Planning application 3/2020/0142

Amended information. Your letter of 29/7/20.

9829-1-2B

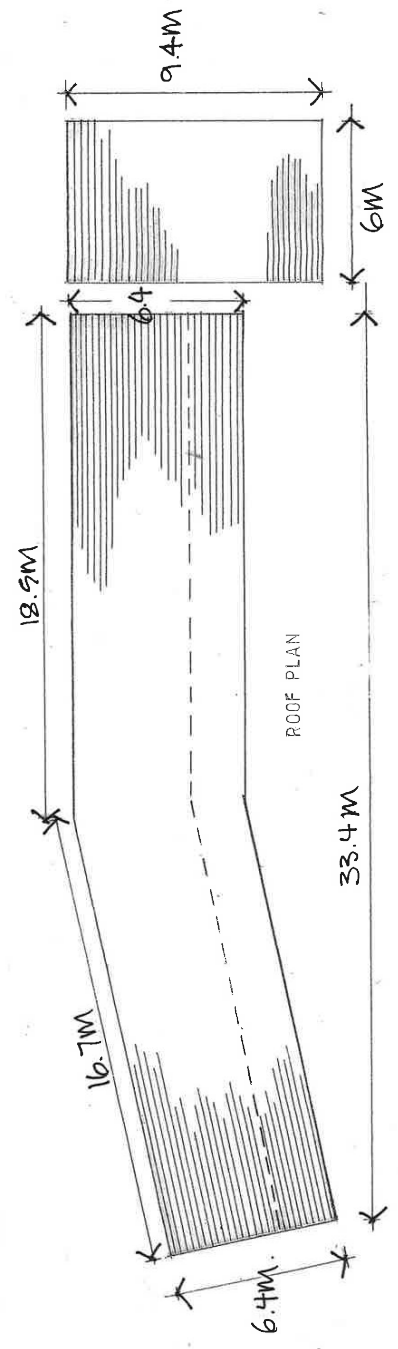
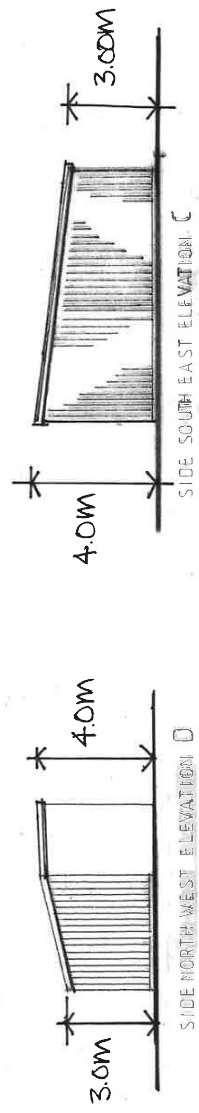
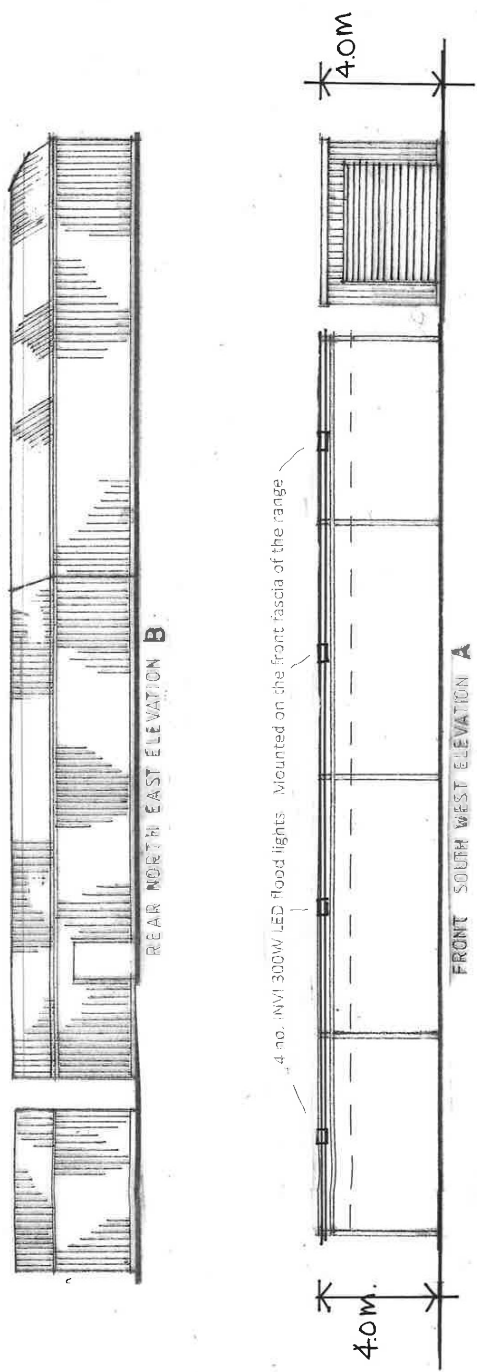
The amended elevation proposals have been added to the application without removal of the original elevations, should this be overlooked both may be authorised!

The existing structure, in its present or amended form, would not be a visual asset to the Ribble Valley, being ugly, utilitarian and totally lacking any charm.

CLATHEROE G.C.
 PROPOSED DRIVING RANGE SHELTER + TRAINING ROOM
 SITE PLAN
 1:1050 JULY 2011 DNI
 spa
 BINGELAND PRACOCK ARCHITECTS
 9825 - 1-6

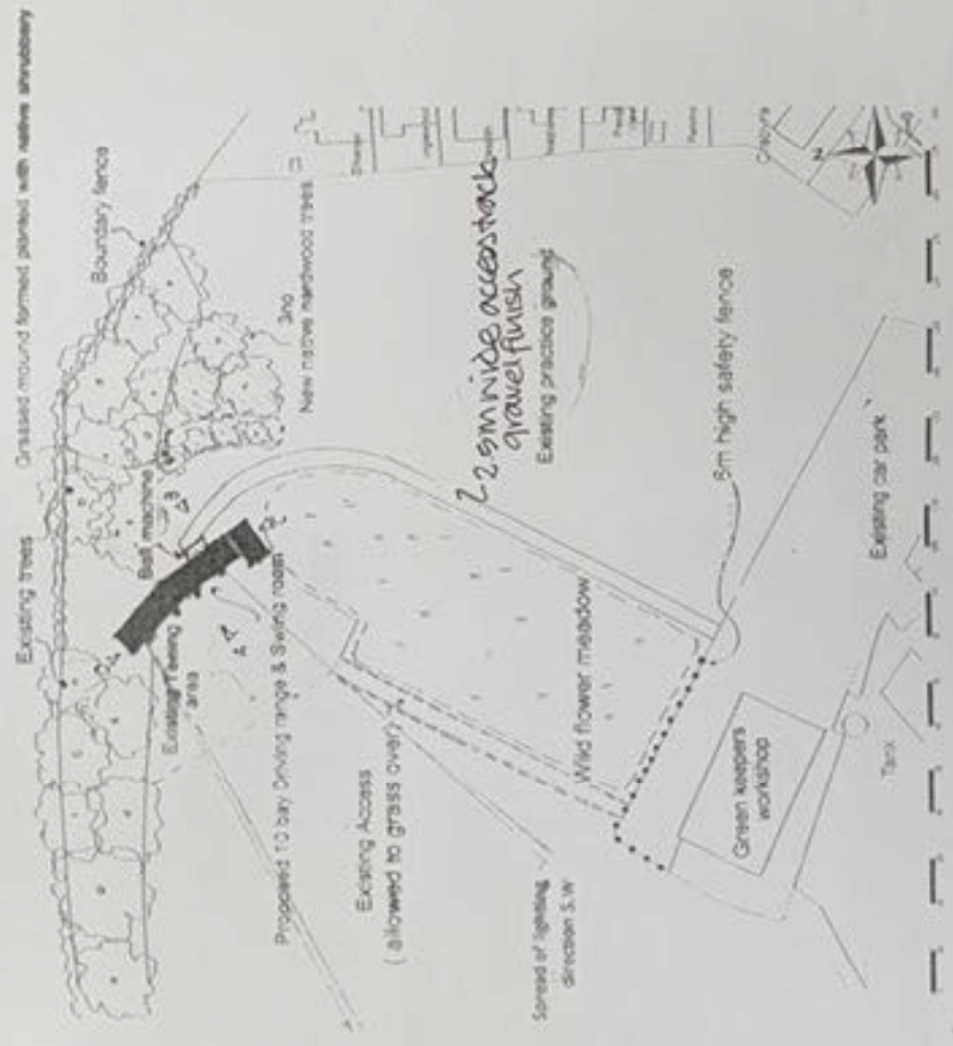
Should this project in any of its forms go ahead, the proposed screen of trees would be welcome. Experience shows this must be made mandatory, and within a given

1.3.6 Pseudo colours, Lightspill area (E)

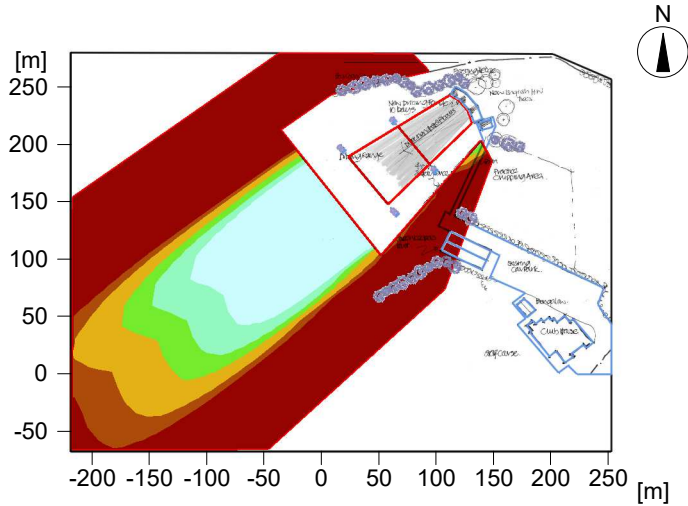
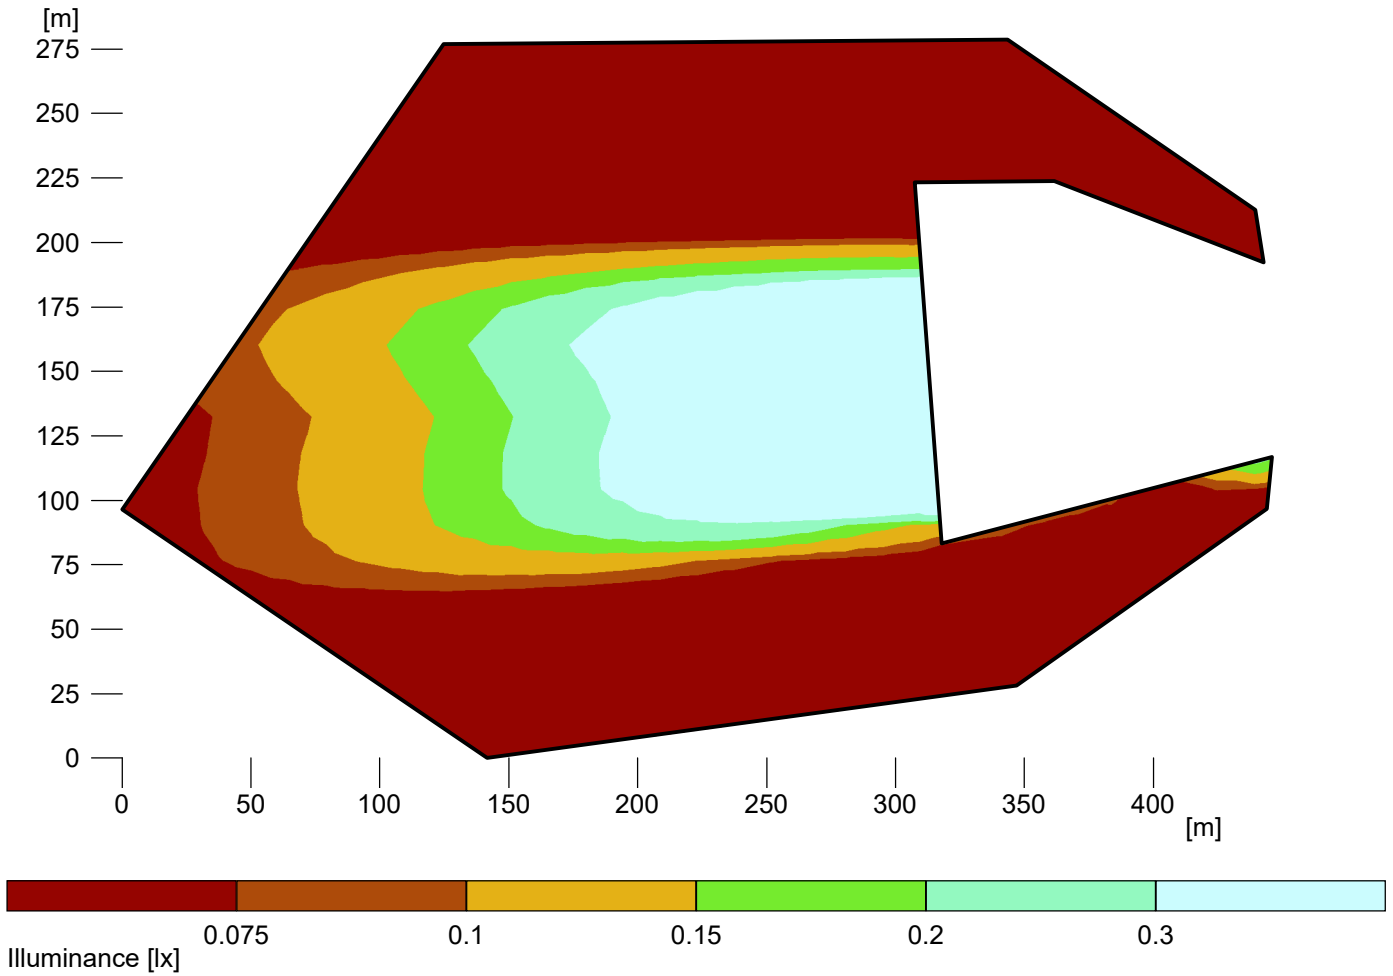
Flood lighting, the request for lighting from 0630 to 2100 hrs a day, 7 days a week, seems excessive for anything other than a commercial undertaking.

This light will obviously add to the current overspill of light from street lighting and the Golf Club car park to further diminish my view of the night sky.

The lighting appraisals show horizontal intensity but not vertical intensity.
